SUBJECT: WDFW COMMENTS ON SP-20-00005 ZIPPERER APPLICATION

Thank you for the opportunity to comment on the SP-20-00005 Zipperer application concerning a proposed short plat on parcel #15148.

ZIPPERER SHORT PLAT, SP-20-XXXX

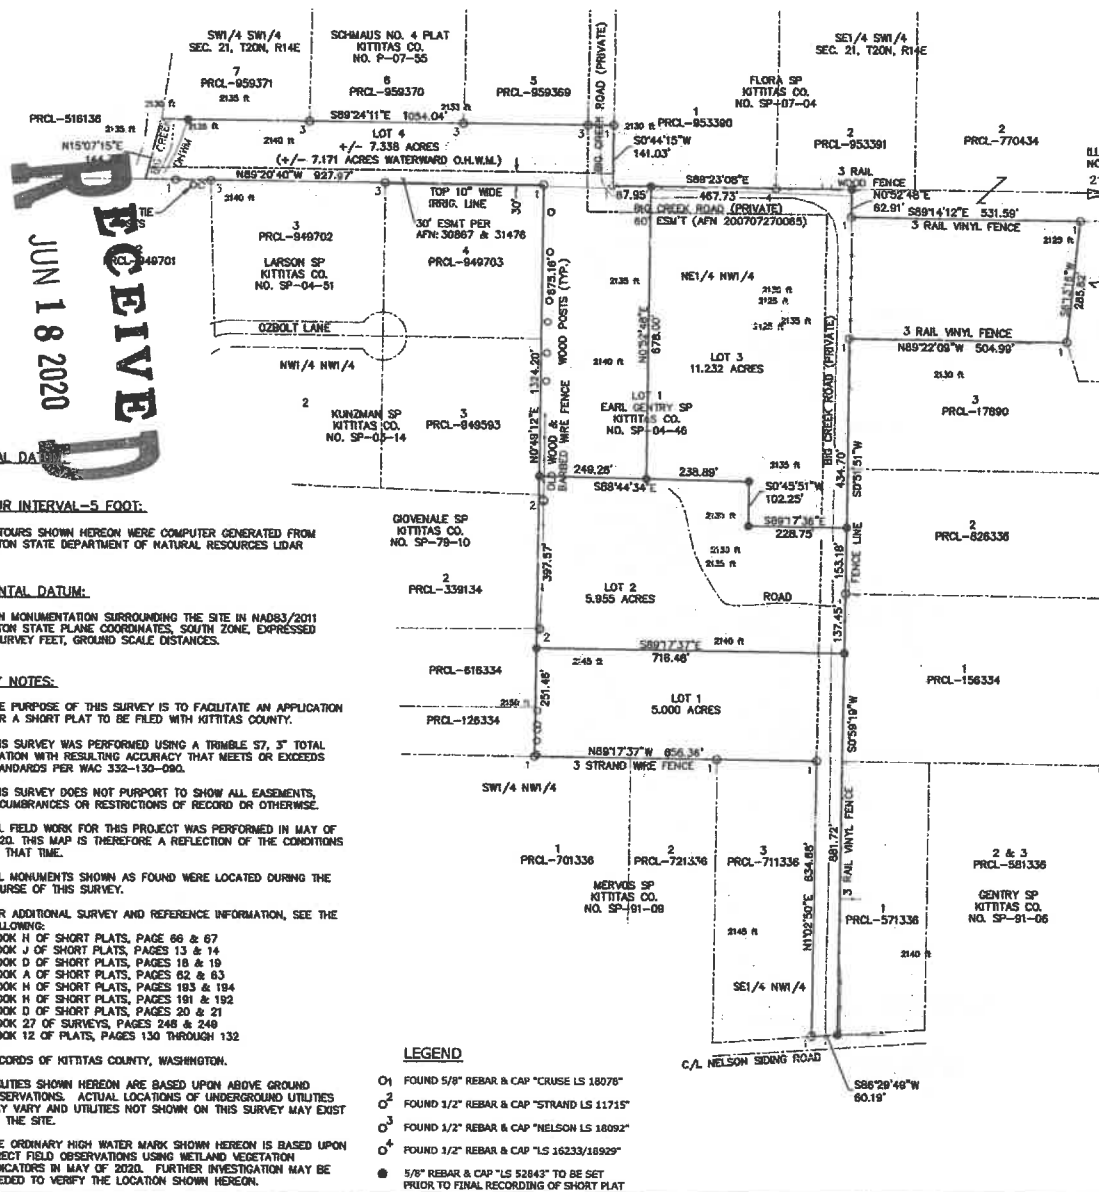
The Survey Map shows that proposed Lot #4 is bordered on the west end by Big Creek, a shoreline of the State of Washington (Type 1 waters). Additionally, this portion of Lot 4 also falls under FEMA Zone C (100 year floodplain).

As such, **the Washington Department of Fish and Wildlife (WDFW) strongly recommends that you apply a setback of 200 foot from the ordinary high water mark (OHWM).** The reason for this is twofold: 1) this will provide the most protection from potential floodwaters; and 2) this distance encompasses the WDFW recommended setback for preservation of the riparian ecosystem, which is delineated by a method called “site potential tree height”.

In addition to this request, WDFW encourages Kittitas County to require the application to provide a full Critical Areas Report prior to short plat approval to ensure that all on-site critical areas are properly identified and accounted for. From review of LiDar there are potential wetland or water features that need to be investigated prior to approval (see image 1). Desktop review of resources and databases is not a substitute for an on-the-ground review of site conditions, and a Critical Areas Report will assist in ensuring that effects to the natural environment are taken into consideration with this development.
